From: MarkHobbs [REDACTED]
Sent: 08 November 2021 10:18
To: Paul Cann
Cc: Glynn Curtis; Sarah Burrow
Subject: RE: Little Sefter Extension, Pagham, Bognor Regis - OWC Application
Attachments: Barfoot - Sefter Barn FC2846.02E SW Drainage.pdf; Barfoot - Sefter Barn FC2846.03E Ext Levels & CF.pdf

From: Paul Cann <Paul.Cann@arun.gov.uk>
Sent: 28 October 2021 12:33
To: MarkHobbs [REDACTED]
Cc: Glynn Curtis [REDACTED] Sarah Burrow <Sarah.Burrow@arun.gov.uk>
Subject: RE: Little Sefter Extension, Pagham, Bognor Regis - OWC Application

PROJECT	BARN EXTENSION BARFOOTS - LITTLE SEFTER PAGHAM RD, BOGNOR REGIS W SUSSEX, PO20 1LN			
	PROPOSED SW DRAINAGE LAYOUT			
DRAWING	FC2846/02			
	REV C			
SCALE	1:125			
	DATE	JAN 20	MH	CHKD -

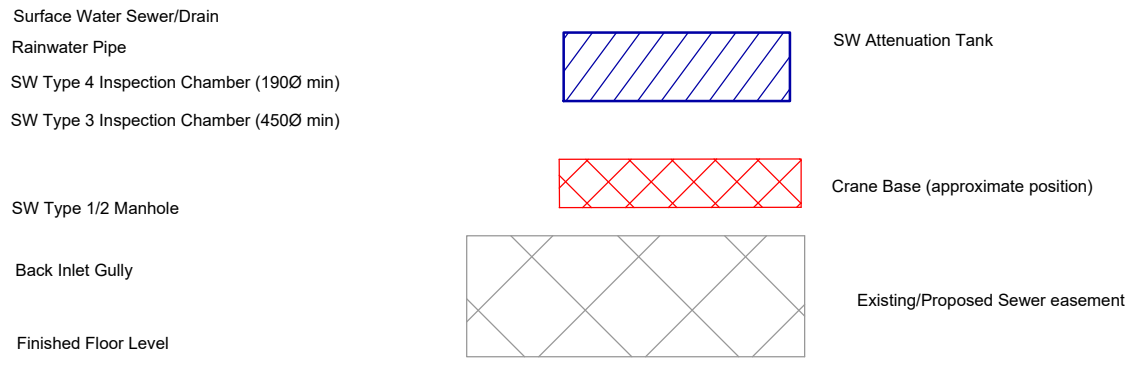
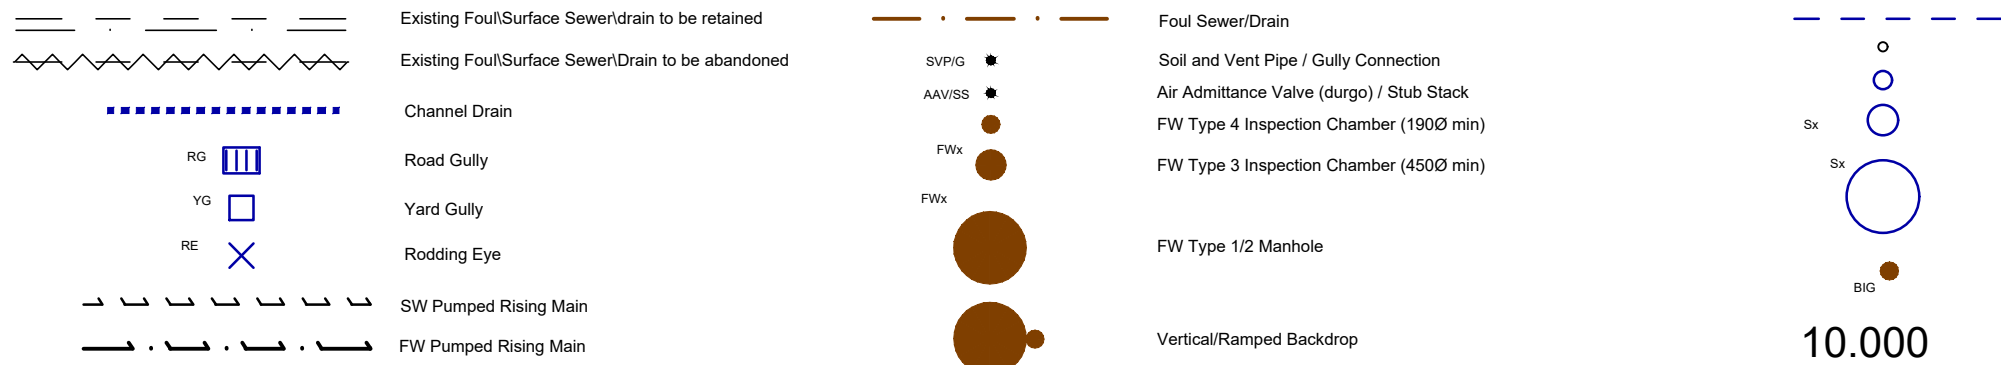
2. I note that important levels ie. existing ditch bed, new channel bed, etc, at still to be confirmed. We need to verify/confirm these levels at this stage.

3. Can we increase channel base width to 500mm but not steepen bank slopes as a result.

4. Have you considered any erosion control measures where flows exiting the new channel will flow over/down what remains of the existing ditch bank.

Topo survey shows that the existing ditch is 1.5m deep. Top of bank was only recorded on one side due to existing dense vegetation, but top of bank is fairly consistent @ approx. 1.4–1.5m AOD in our area of interest. See attached topo. This would suggest the base of the existing ditch is circa 0.00m – which is what we have noted on our drawings to date, and we wouldn't expect it to be widely different from this. Given that the outfall from the flow control is at 2.3m we have a significant leeway to enable a connection to the ditch so do not think that levels are an issue in this location. Trust that you are happy with the data/assumptions shown on drawings without any further survey work being required Agree & ok

Yes - No probs ok

In short no given that the flow rates from the storage pond are so low – currently suggested at 5l/s May be even lower yet, depending on outcome of item 1!

Alternatively we could adjust the new ditch bed level to tie in with the existing ditch bed level? Yes you could or say connect in at 0.25.

SHE-0076-2000-0400-2000
 Hydro-Brake® Optimum

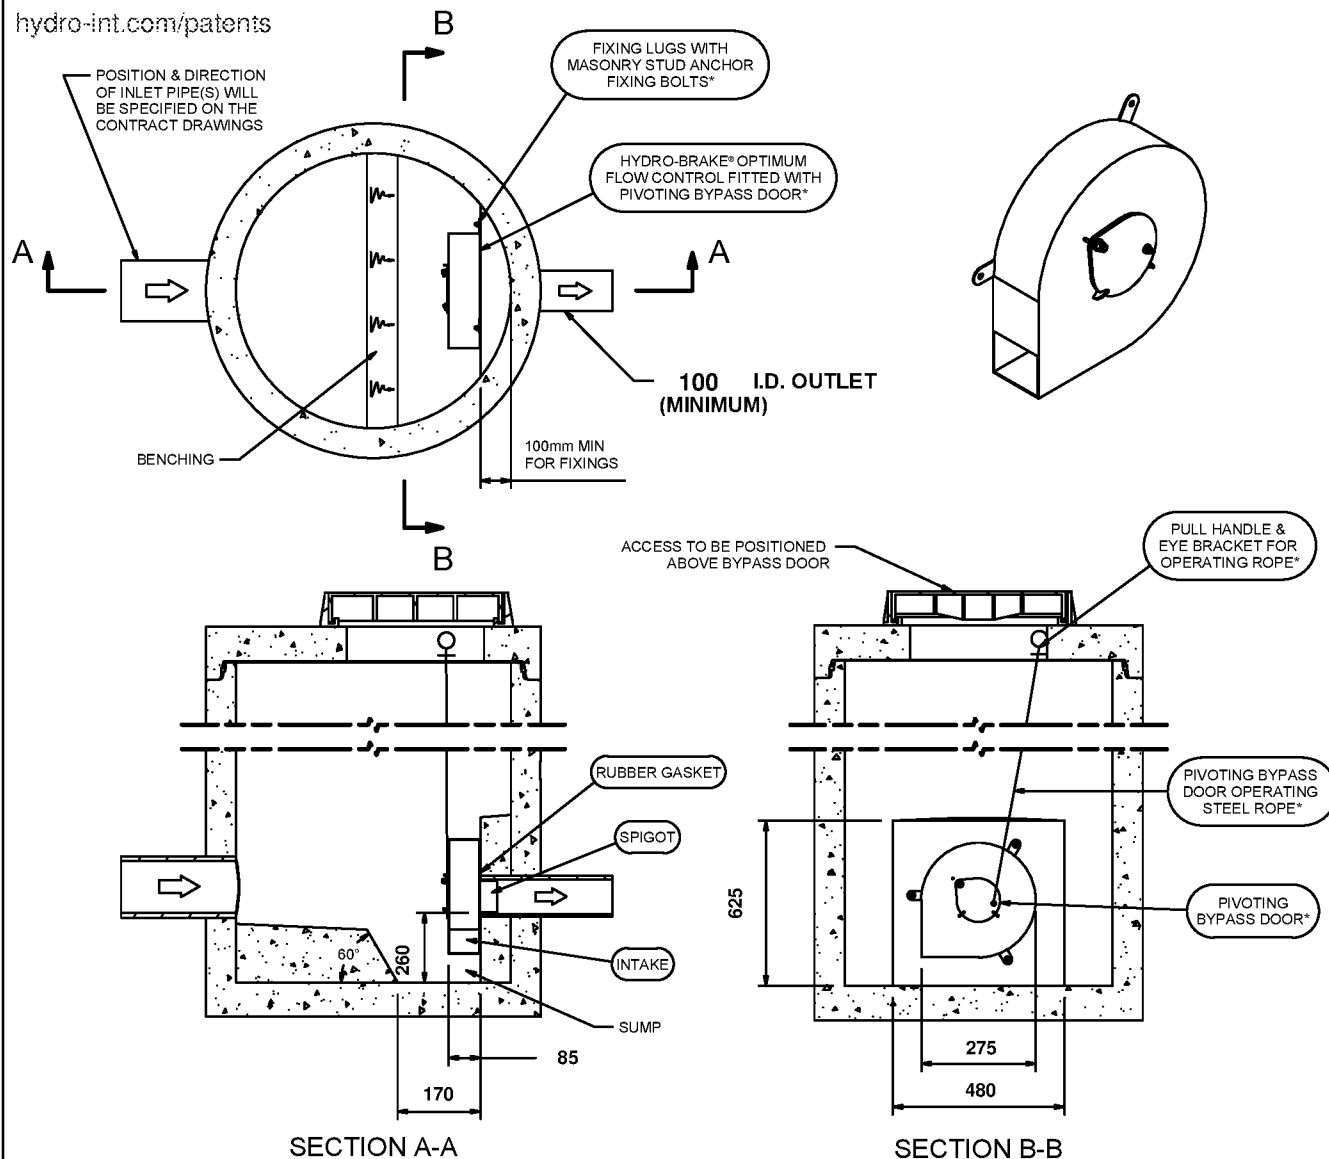
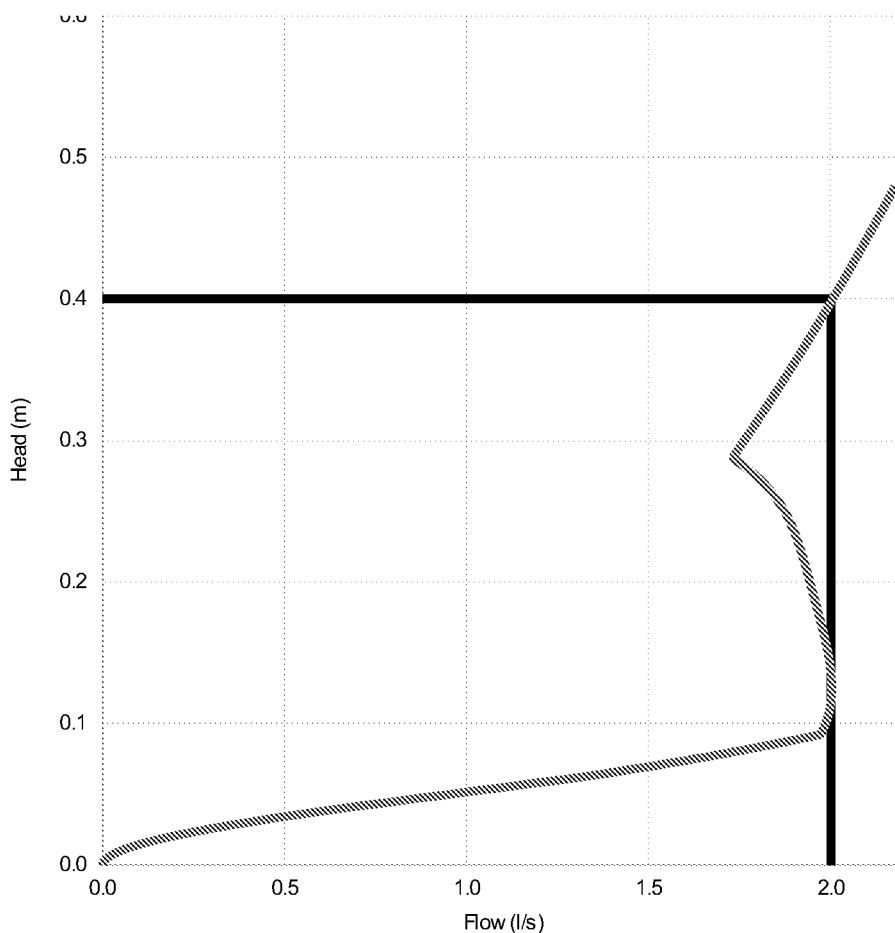
The discharge rate would be assessed/agreed as part of the DOC application associated with P/38/21/PL (likely to be looked at by others). However, with the landscape plan in mind, I would suggest restricting to 2 l/s (normal requirement is to restrict to QBAR based upon the positively drained area) but incorporate measures to reduce the risk of blockage/provide visual indicators of a blockage issue ie. specify suitable sloped face/bar spacings (45 degree) trash screen and a visible overflow arrangement ie. spillway, so issues can be easily seen. This can all be tied up in a suitable management & maintenance manual, as regular maintenance also helps reduce the risk.

Updated drawings with discharge restricted to 2l/s as requested 🌐 plus picking up your previous comments.
